PRELIMINARY DRAINAGE REPORT

GRANDVIEW RESERVE FILING NO. 1

El Paso County, Colorado

DATE:
December 10, 2021

EXISTING CONDITIONS - DRAINAGE MAP

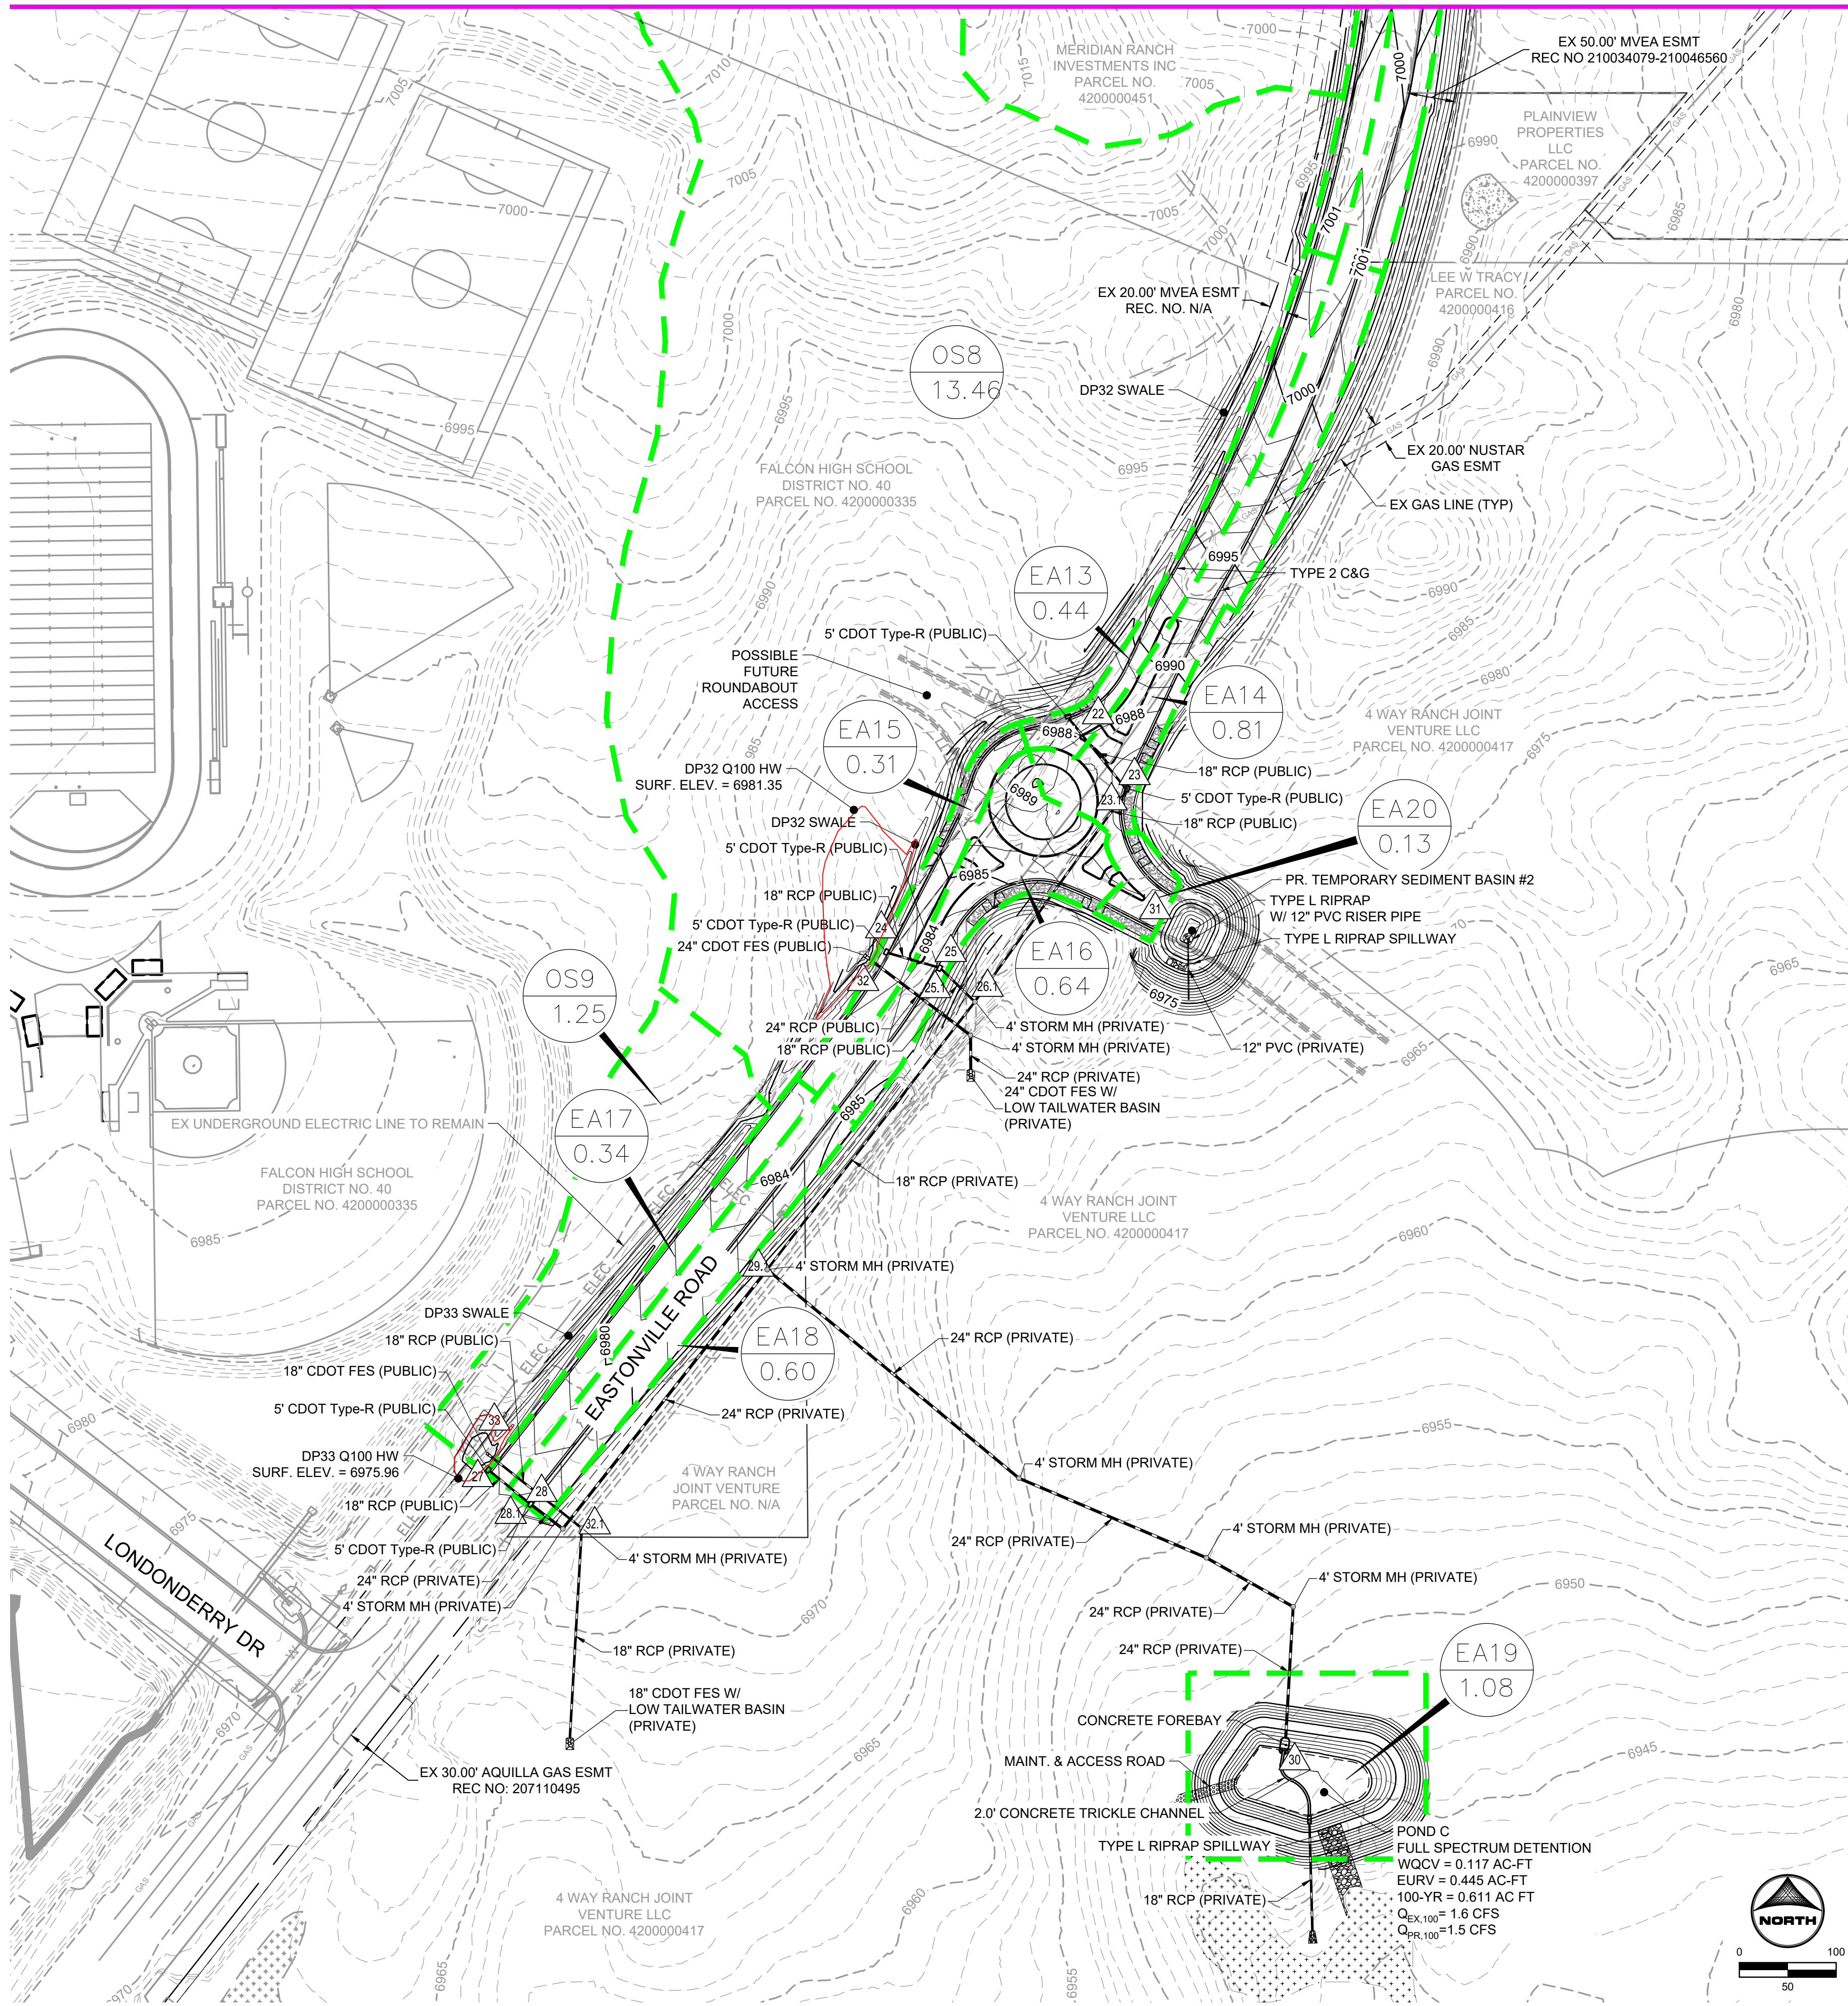
↑ There should be at least 7 onsite and offsite existing basins - break these up as appropriate. See Existing Condition plan redlines.
